SUBMISSION TO NWRL RE ROBERT ROAD CHERRYBROOK

Application number: SSI-5414

My name is Christina Wang, the resident on Arundel Way Cherrybrook. I wish to strongly object to Robert Road being used as a feeder road to the yet to be constructed Cherrybrook Railway station.

Figure 6.12 Cherrybrook Station - Indicative vehicle and pedestrian movements

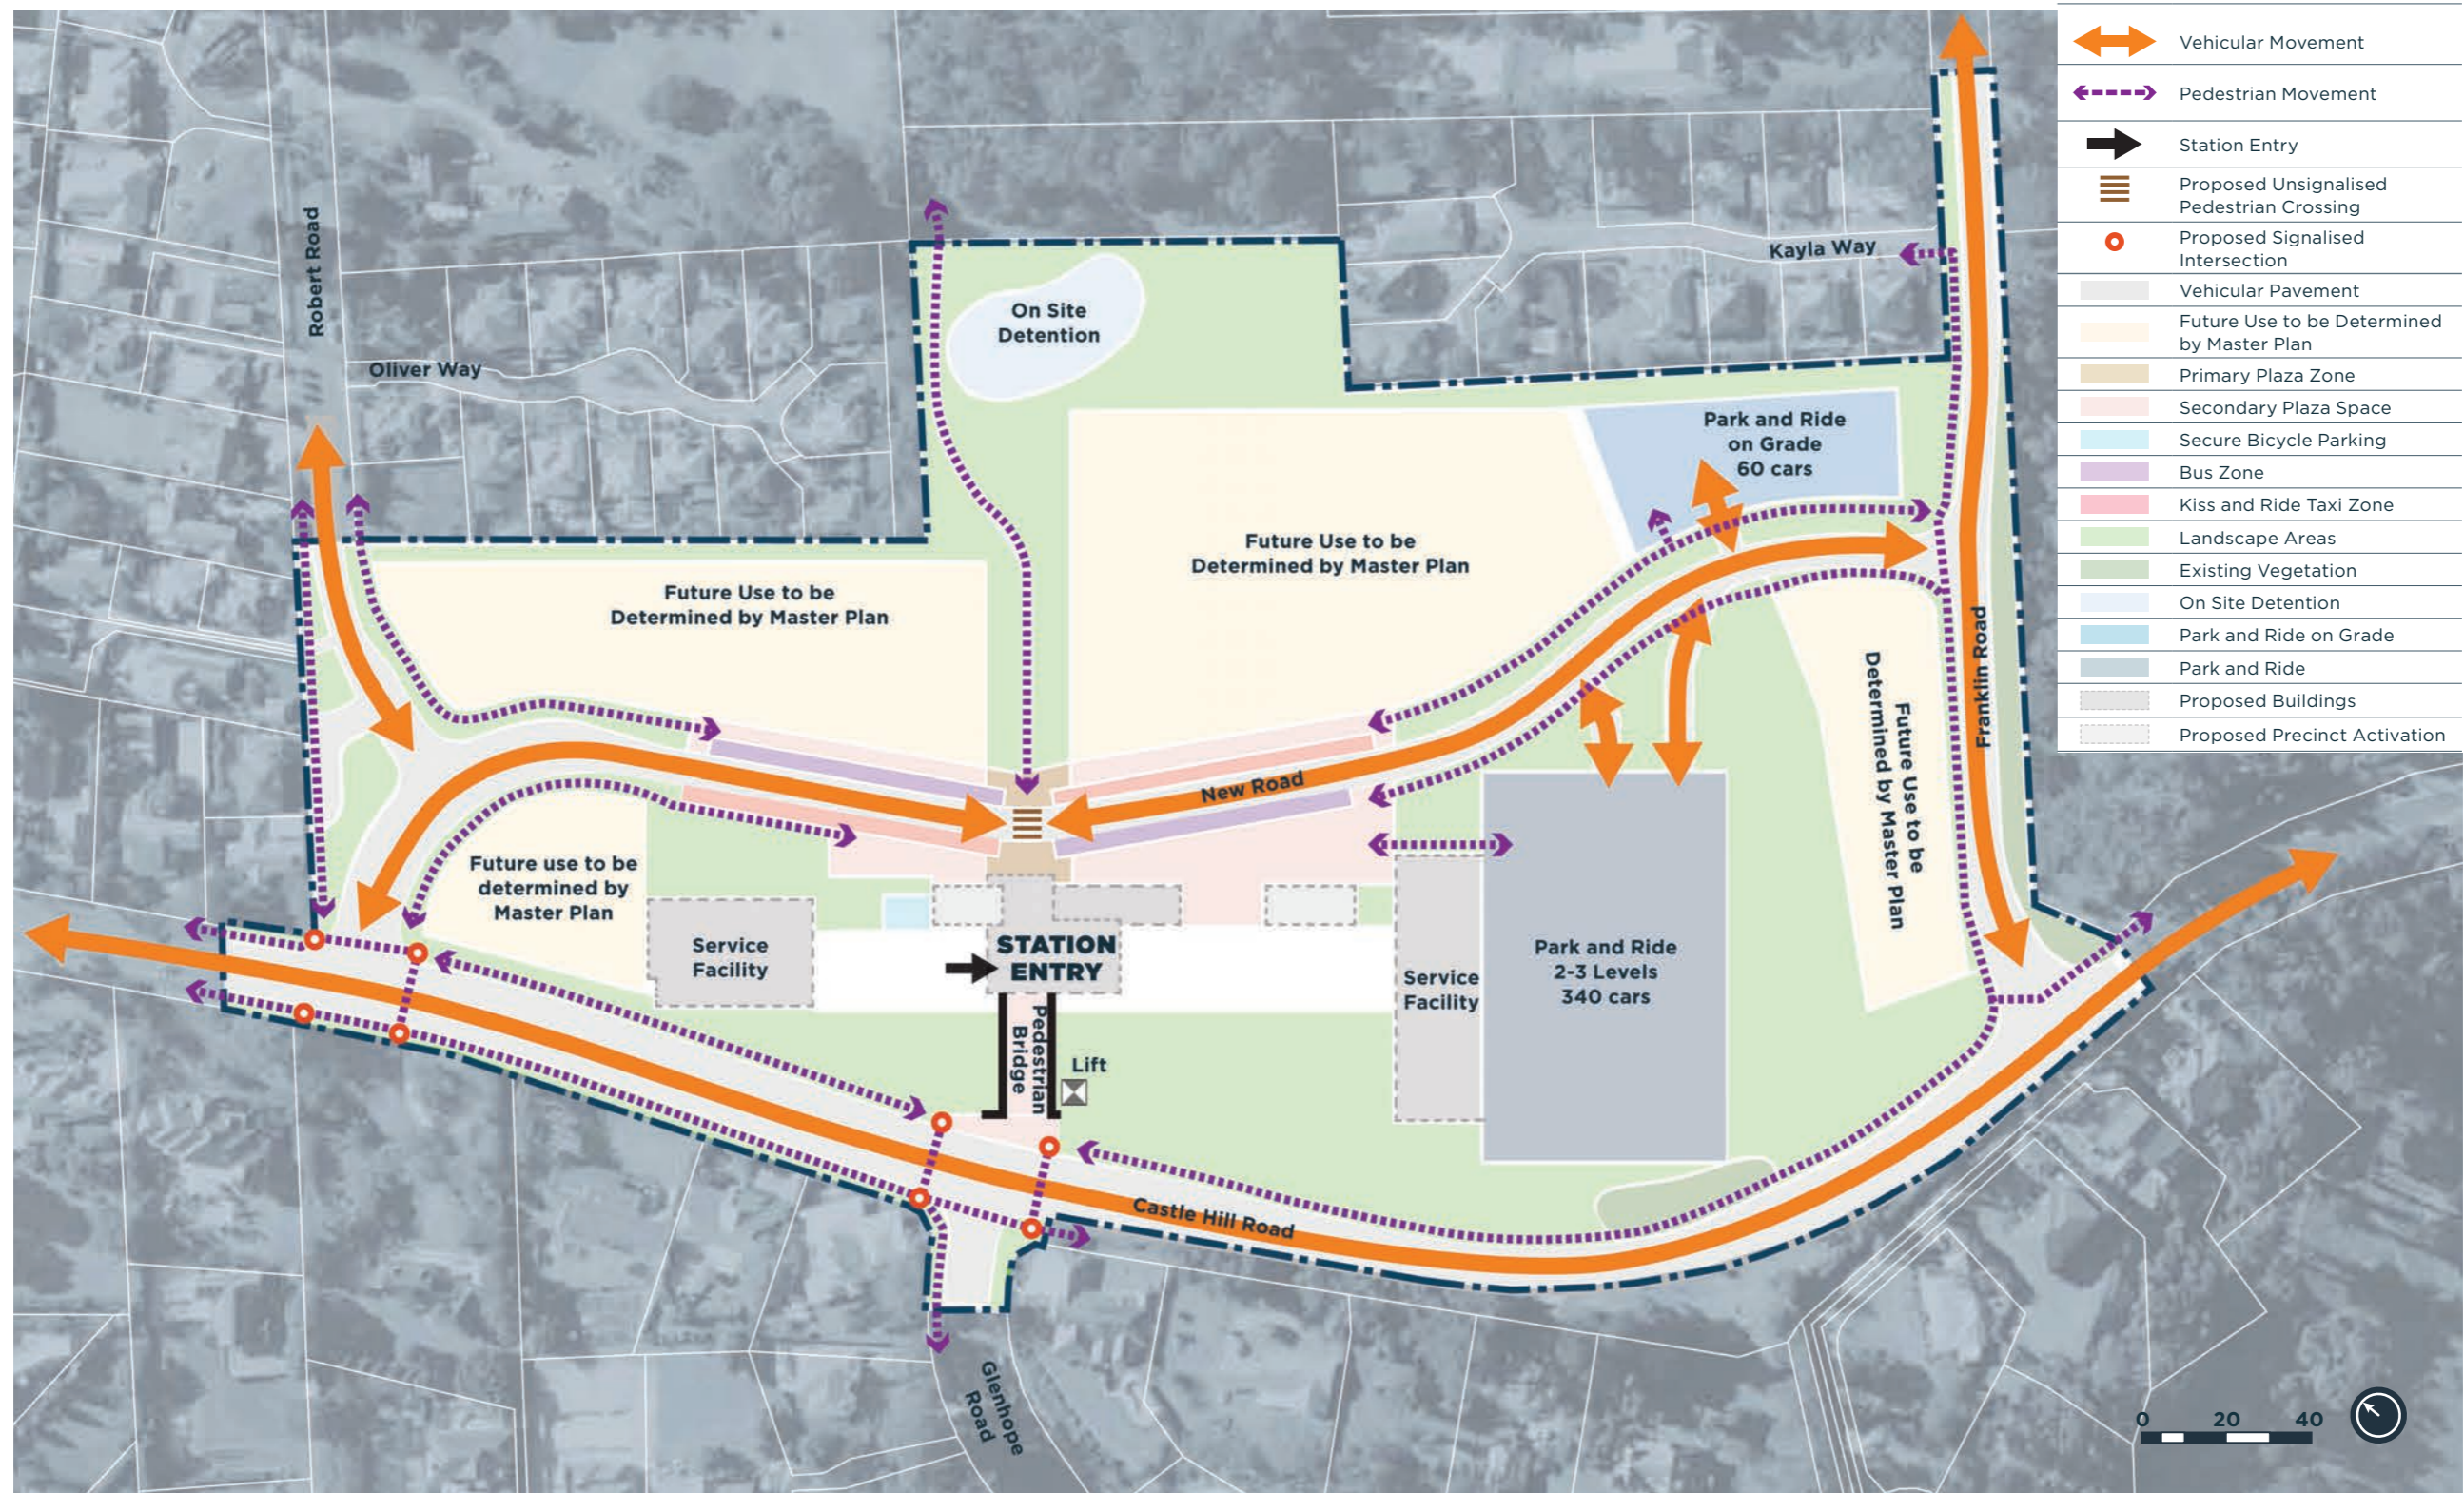
Specifically I and my family object to public transport, notably buses, using Robert Road to access the new station.

- 1. Robert Road is a narrow road designed for low numbers of vehicles. It is not designed for heavy traffic, particularly large vehicles such as buses.**

- 2. The absurdity of the proposal to use Robert Road is further highlighted by the more sensible option of using County Road and then Castle Hill Road. County Drive is clearly designed for heavy traffic. Robert Road is not. We therefore propose that buses heading south on County Drive continue and turn left into Castle Hill Road and head towards Cherrybrook station, instead of the NWRL proposal of buses heading south on County Drive turn left into John Road and right into Robert Road and then south into Robert Road and onto Cherrybrook Station.**

- 3. Contrary to the NWRL proposal, traffic heading South on County drive turning left into Castle Hill Road at peak traffic times encounters very little traffic. And traffic heading east on Castle Hill Road in morning peak time does not slow down until after the station site has been passed. Traffic turning right onto Castle Hill Road does encounter delays, but this is in the opposite direction!**

- 4. Safety issues are paramount. Robert Road is a quiet street, with pedestrians crossing the road at many points, and often, to get access to the park at the corner of Dalkeith Road. No pedestrian crossing exists.**

- 5. Cars existing Arundel Way will not be able to exit safely. The increased traffic of large vehicles will obstruct vision. This also applies to residents of other cul-de-sacs off Robert Road such as Louise Way and Oliver Way. Accidents are bound to happen with the toxic combination of large vehicles and a narrow street.**
